Project Name : Land off Camp Road, Upper Heyford

Job No : 22-192

Note Title : Highways Technical Note

Date : September 2023

Road 3  
Horiz. 1:500 Vert. 1:50

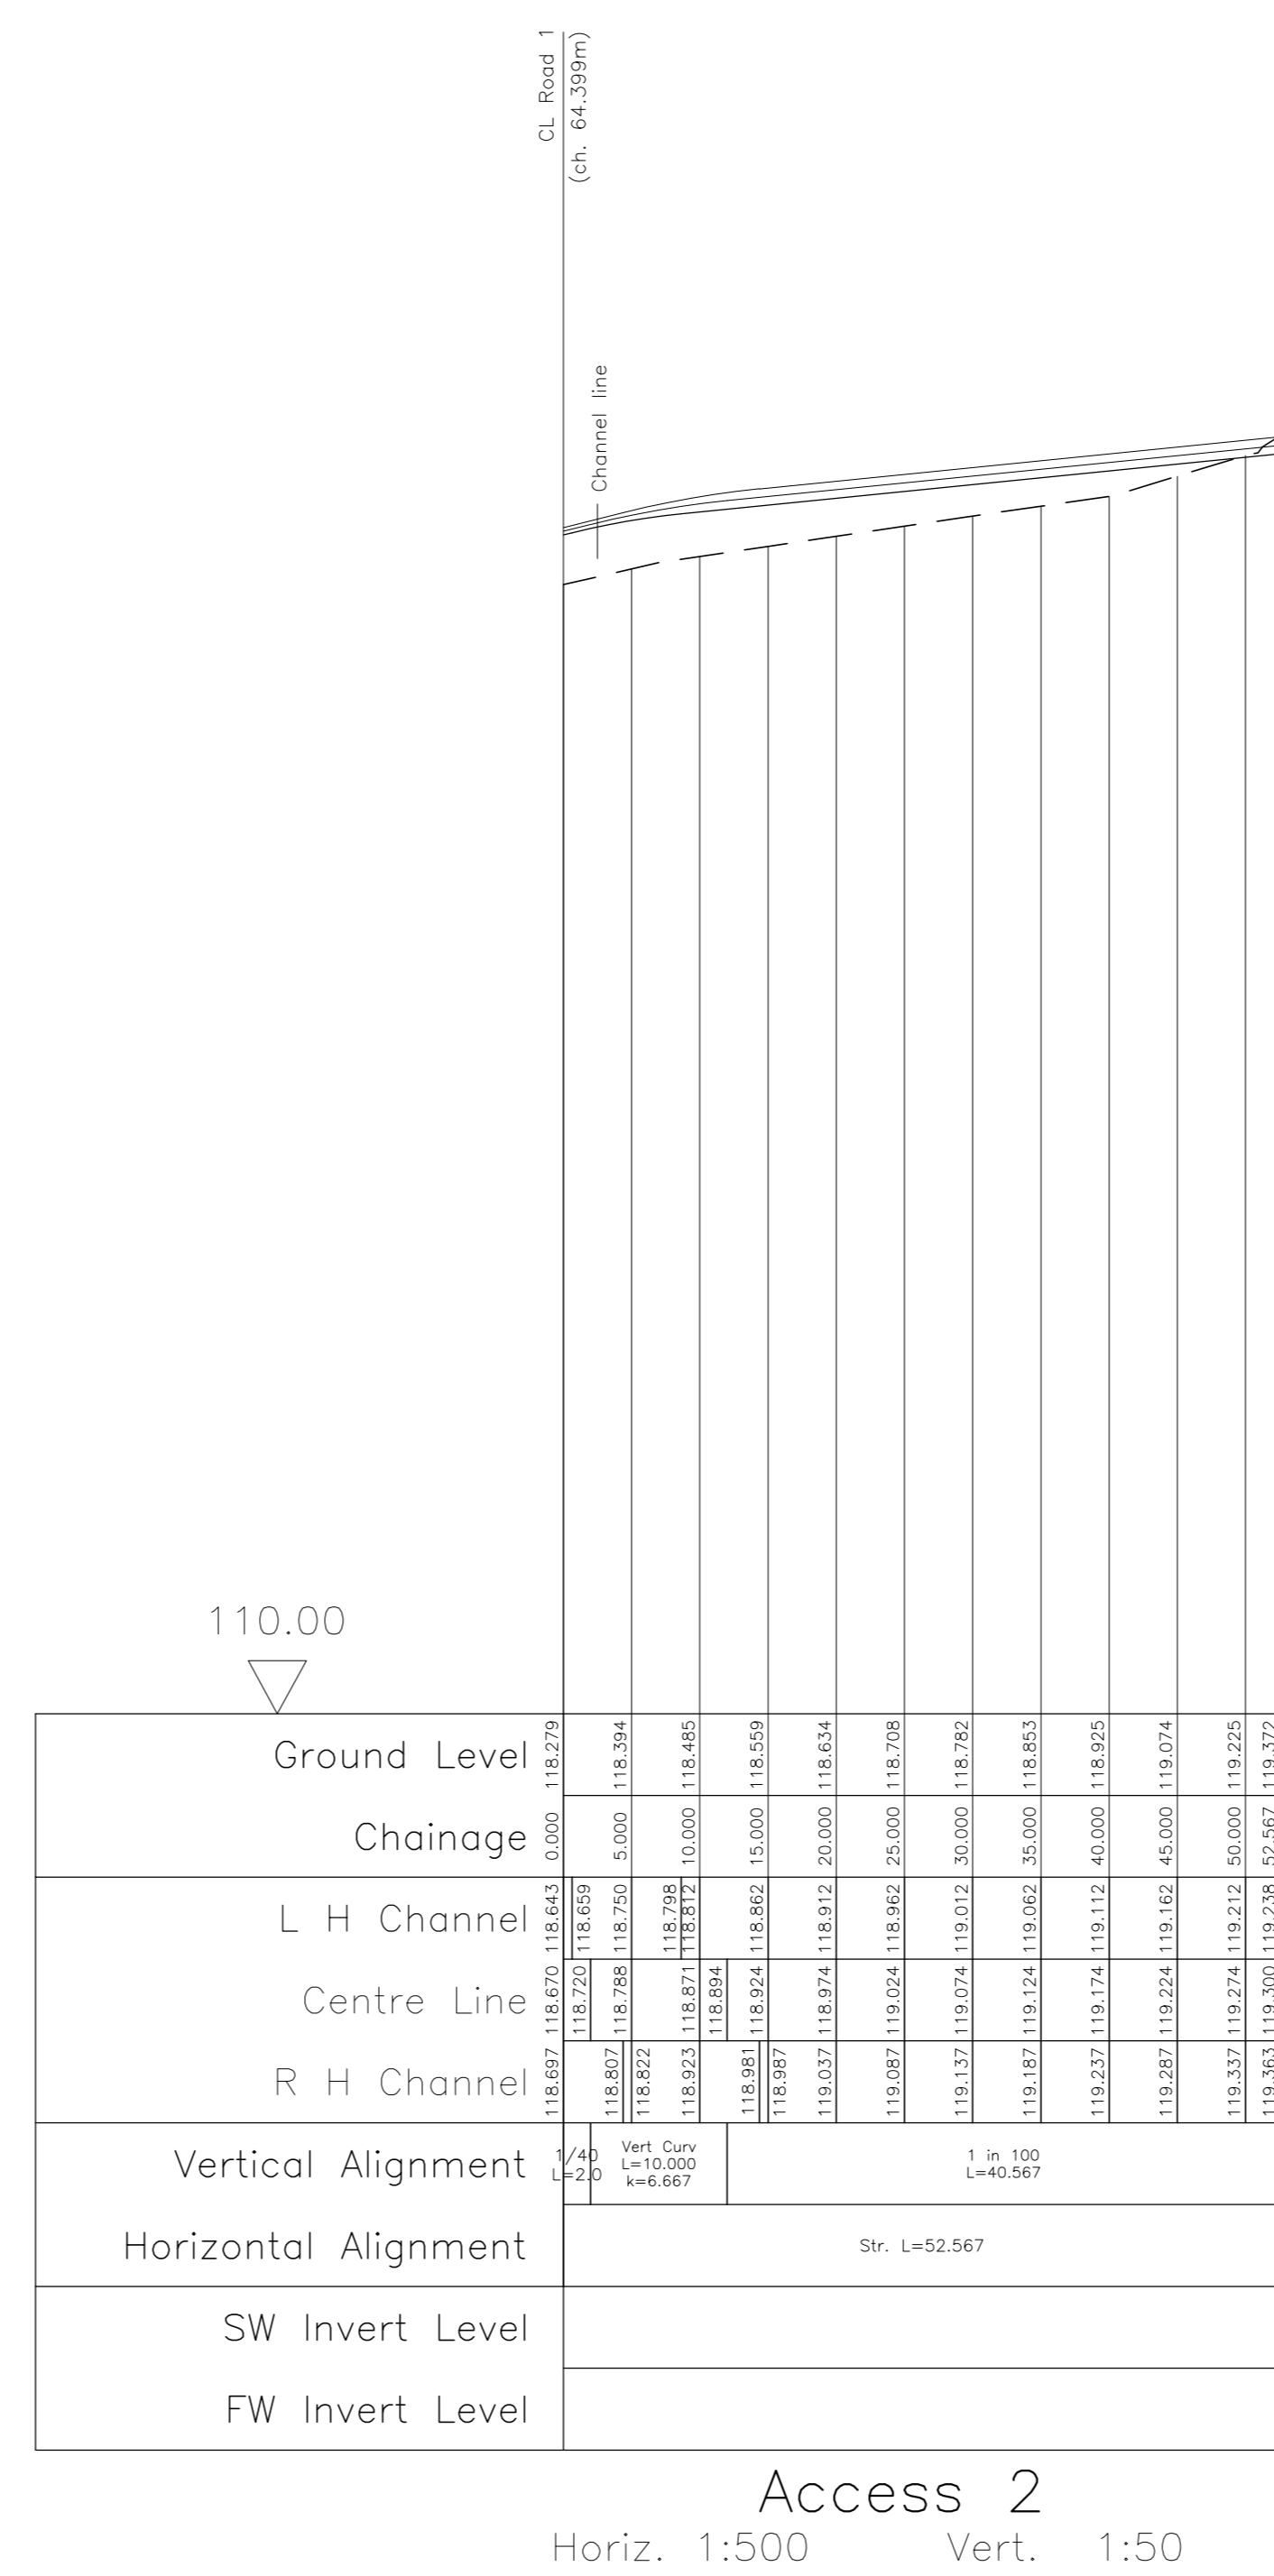
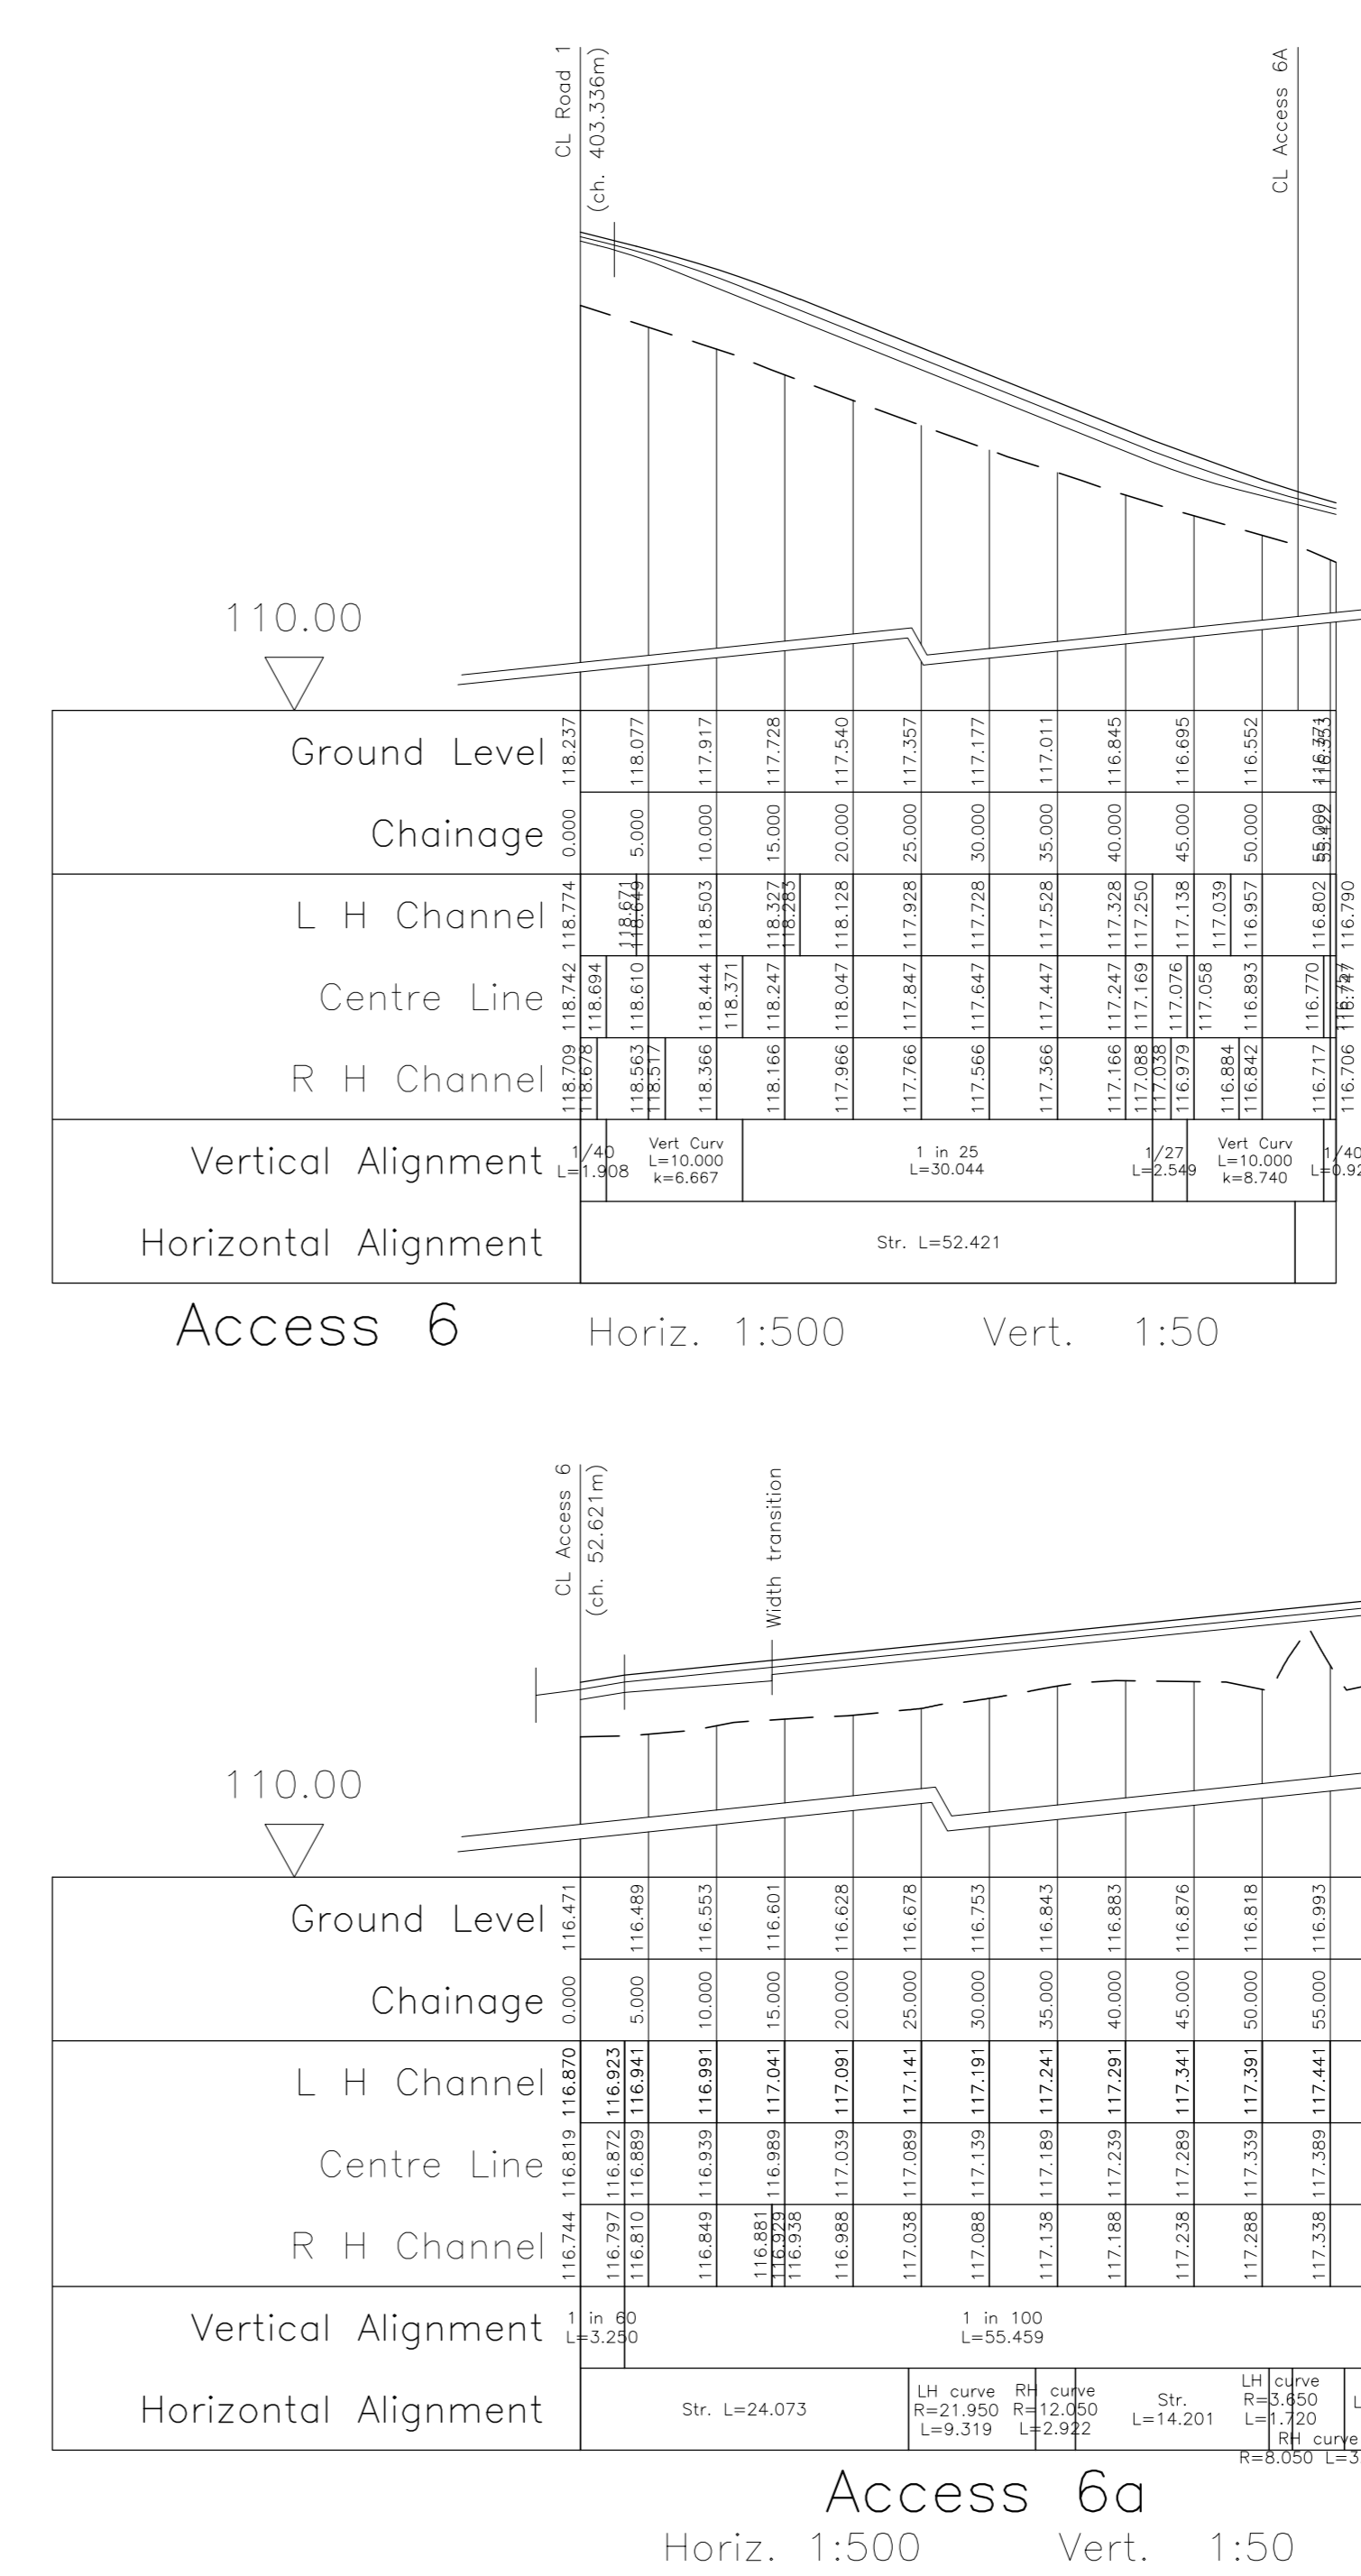
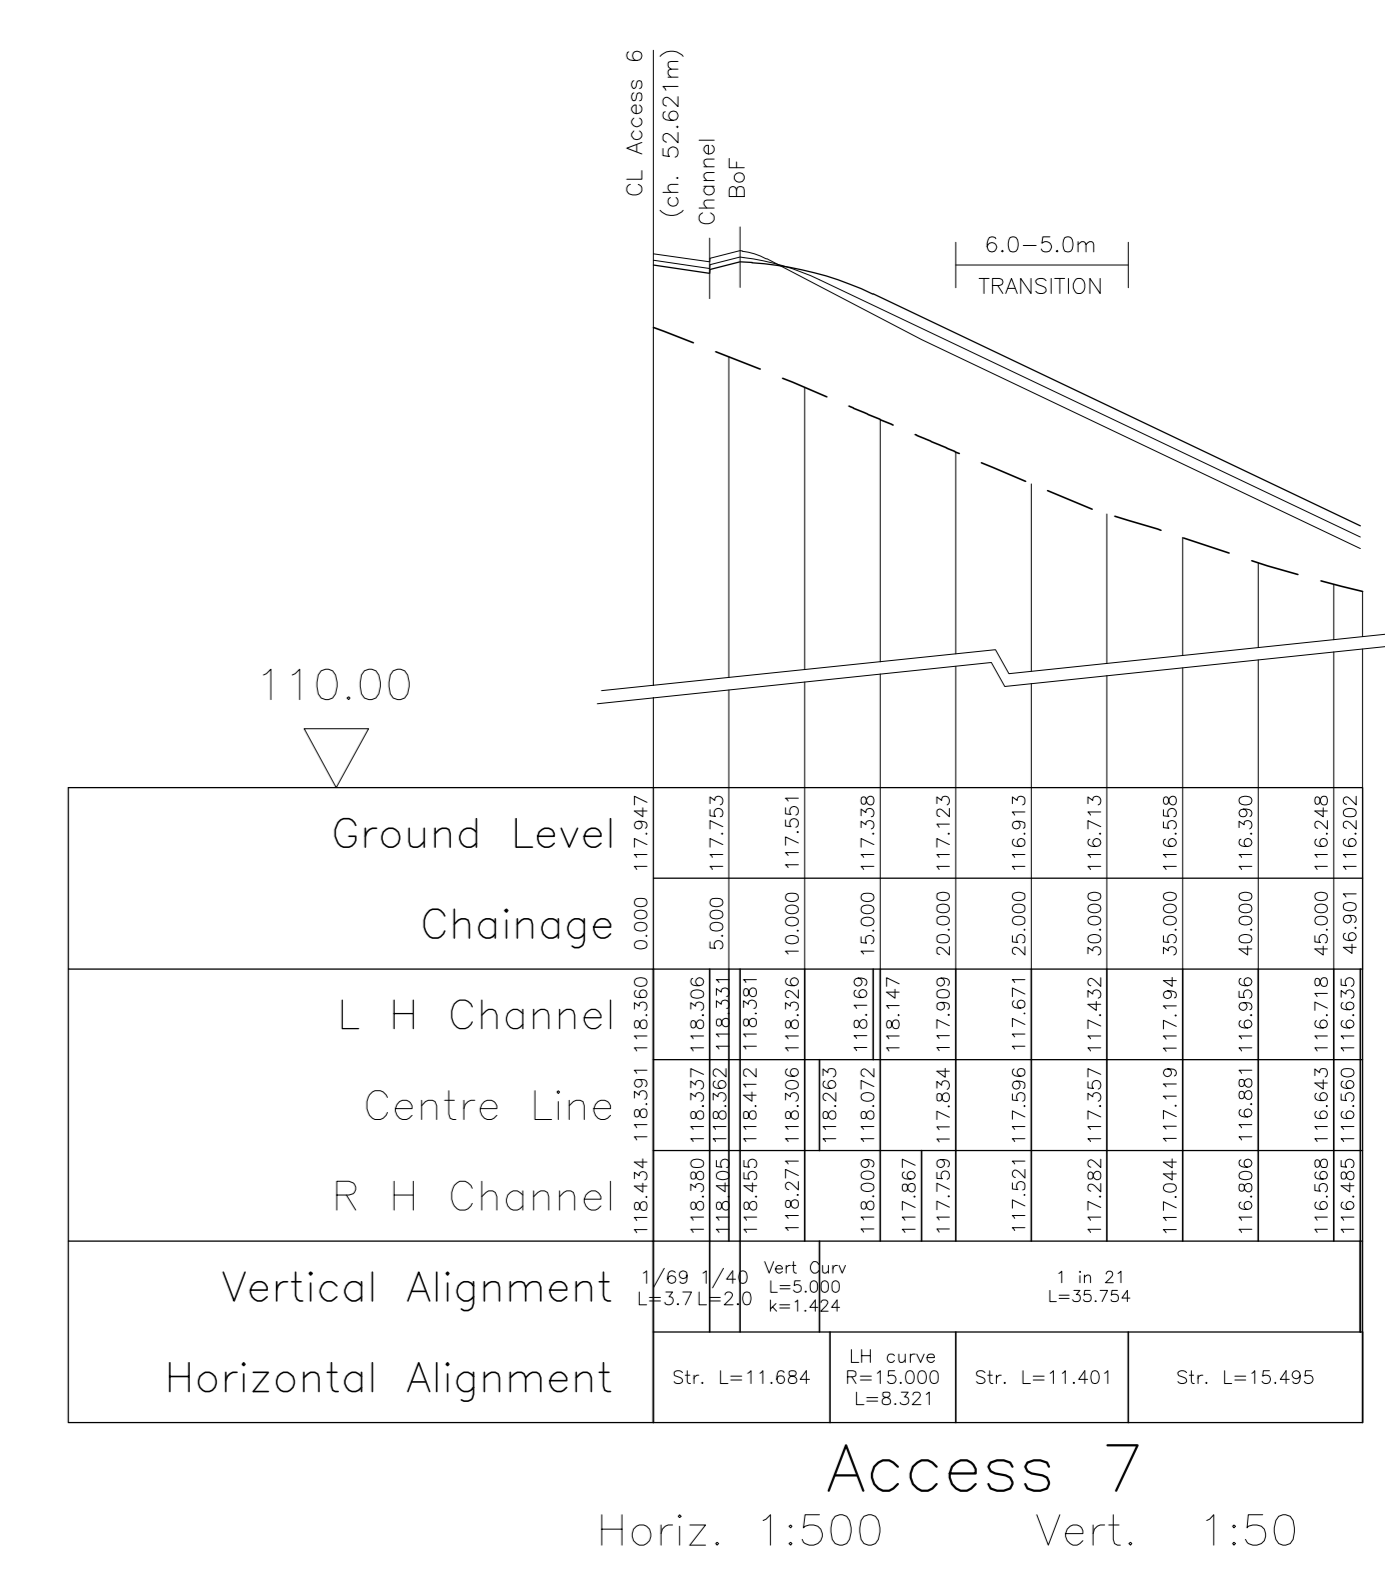
- A long section indicating the vertical alignment will be required to determine appropriate carriageway and footway gradients. They will need to be DDA compliant i.e. maximum 1:20 or 5%.

2.2.15 As requested by OCC Highways a number of long sections of the spine road have been produced to demonstrate the gradient of the adoptable highways; gradients are less than 1 in 20

(5%) and are therefore compliant with the Disability Discrimination Act (DDA). This is shown on **Drawing 22-192/109**.
